**From:** Simon Davis  
**Sent:** 20 December 2017 16:16  
**To:** 'Angus Murdoch'  
**Subject:** RE: CLUED update

My Team Leader has said that AL/77/17/CLE will be issued this week.

We now have a locum solicitor in place to cover Delwyn Jones who is off sick and this person is now looking at Application AL/78/17/CLE. In researching the case this afternoon to respond to some of his questions, I have identified three additional items that I need your further assistance with:

Site Block Plan @ 1:1250

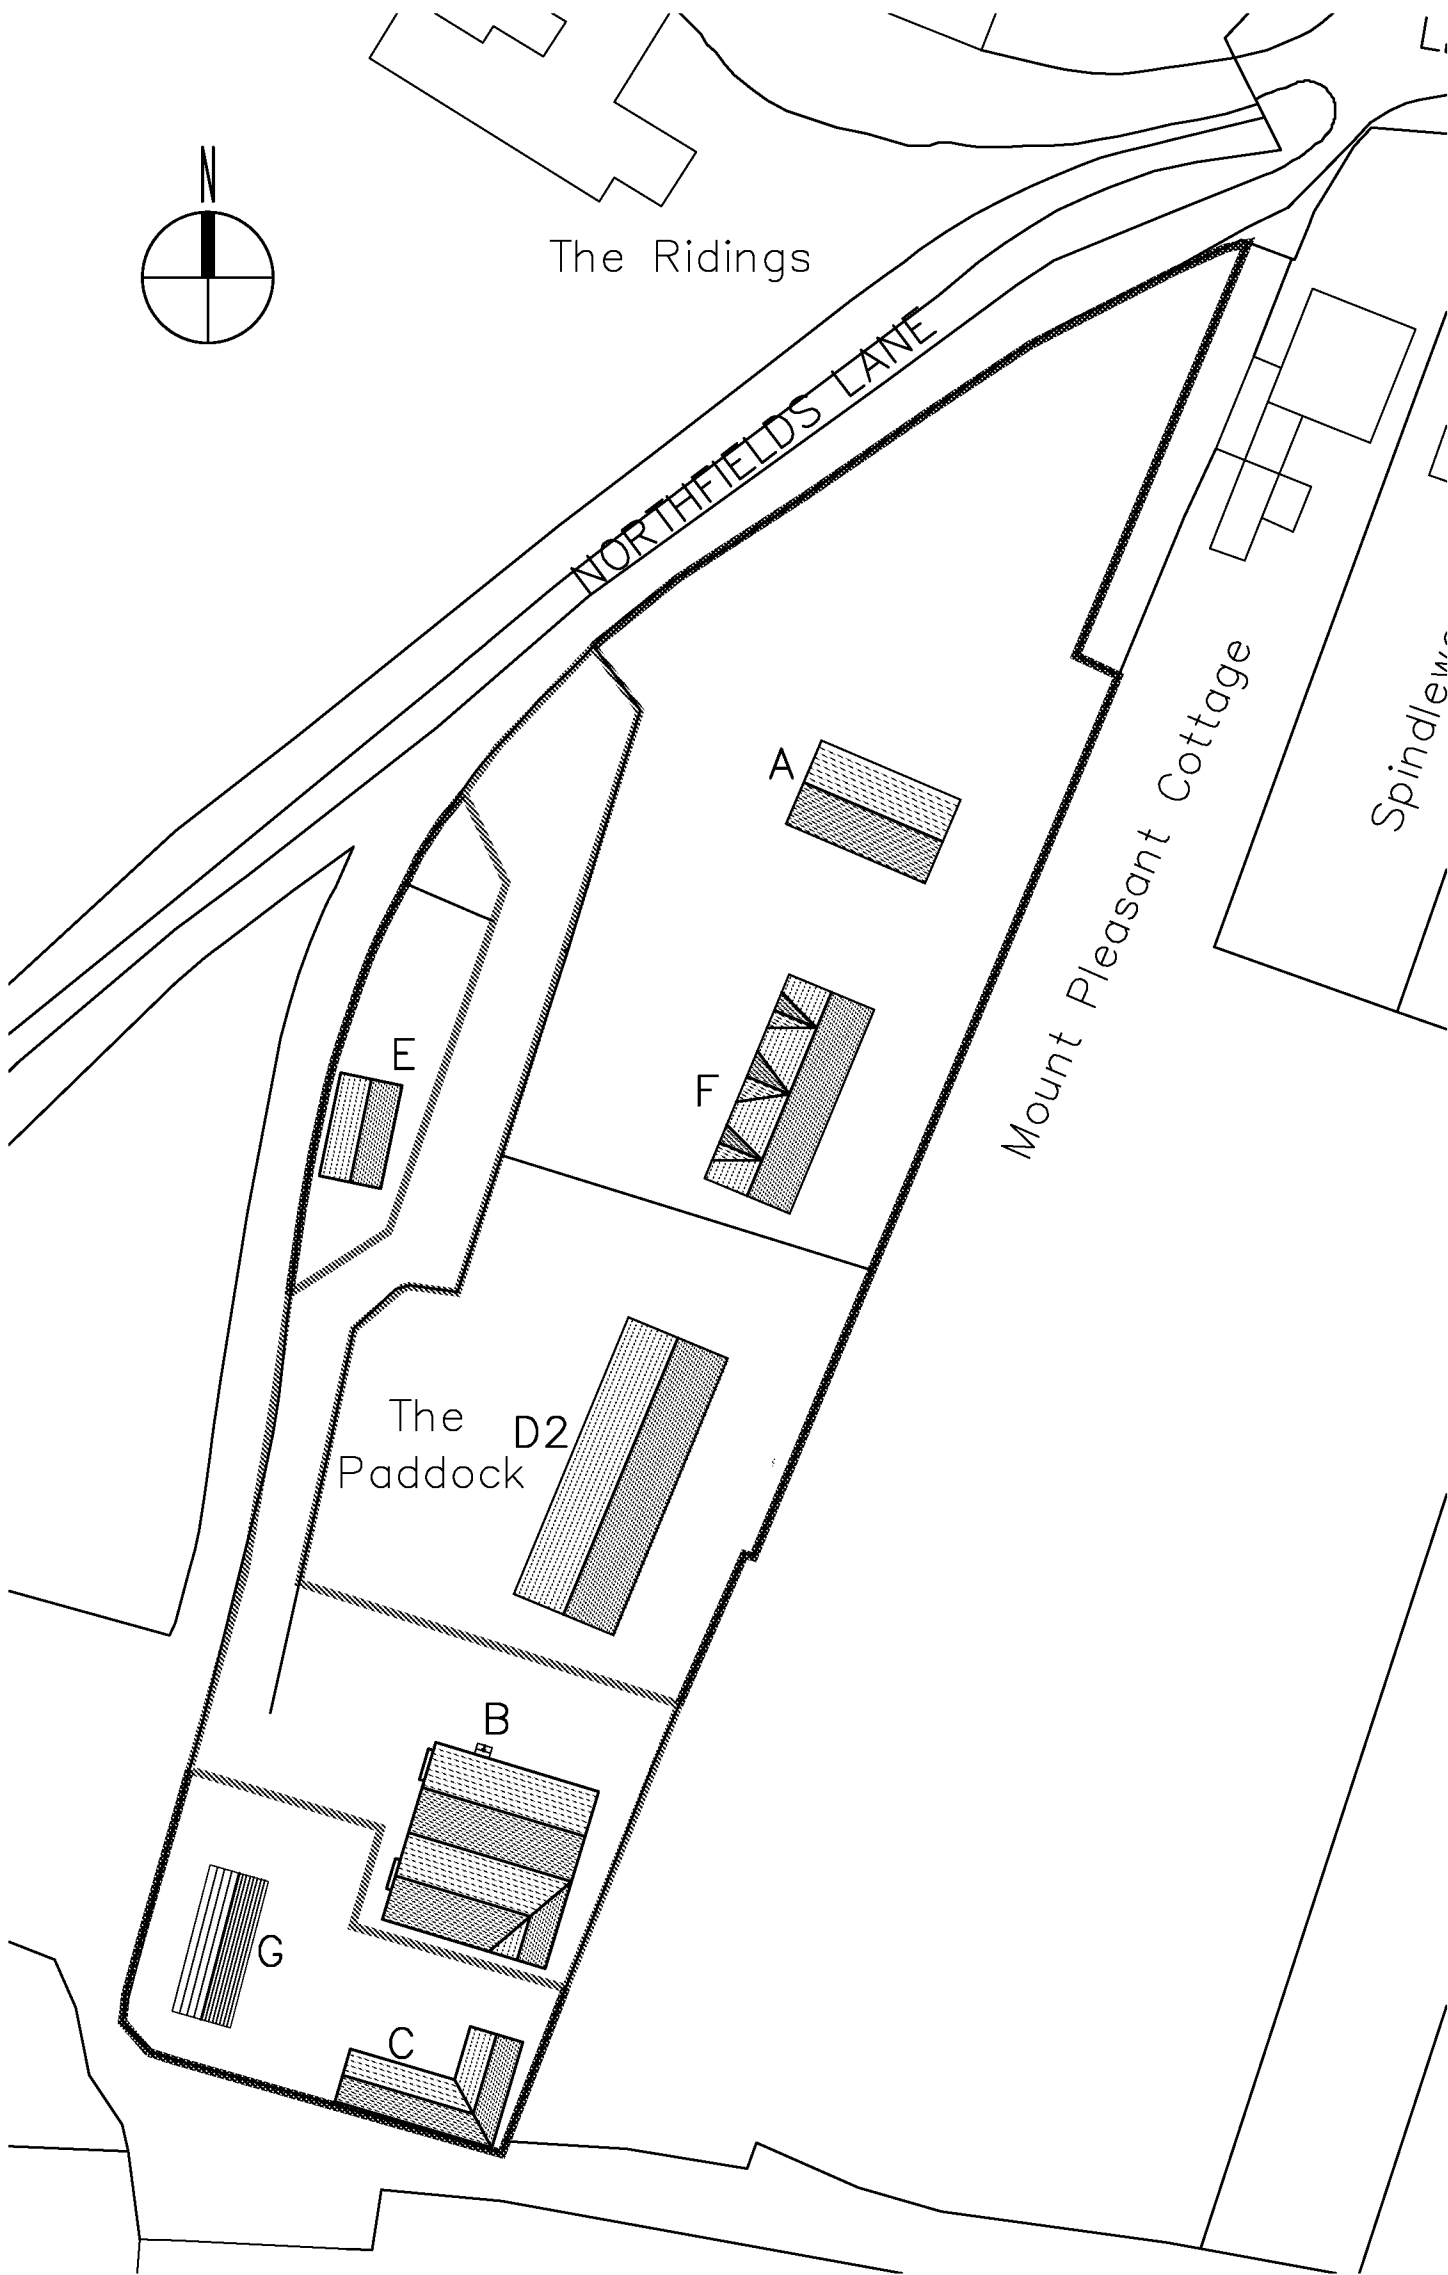
- (1) I can't see any evidence anywhere for the size of curtilage as indicated by the red edge. This red edged area is greater than the fenced off area around the front of the building on the site. Can you advise why the red edged area is greater/what the evidence is for the curtilage as applied for.
- (2) The submitted drawing has an unlabelled floorplan and I note there are photos of different rooms in the unit. However, can you provide a labelled floor plan preferably one which references back to the photos so it is easy to tell which room is used for which and what it looks like. I may then have to revisit the site to check this.
- (3) Can you also confirm when each room was actually converted. I note that Mr Searles evidence states that conversion began in 2010 and was complete by December 2012. It would be helpful to know which rooms were converted when.
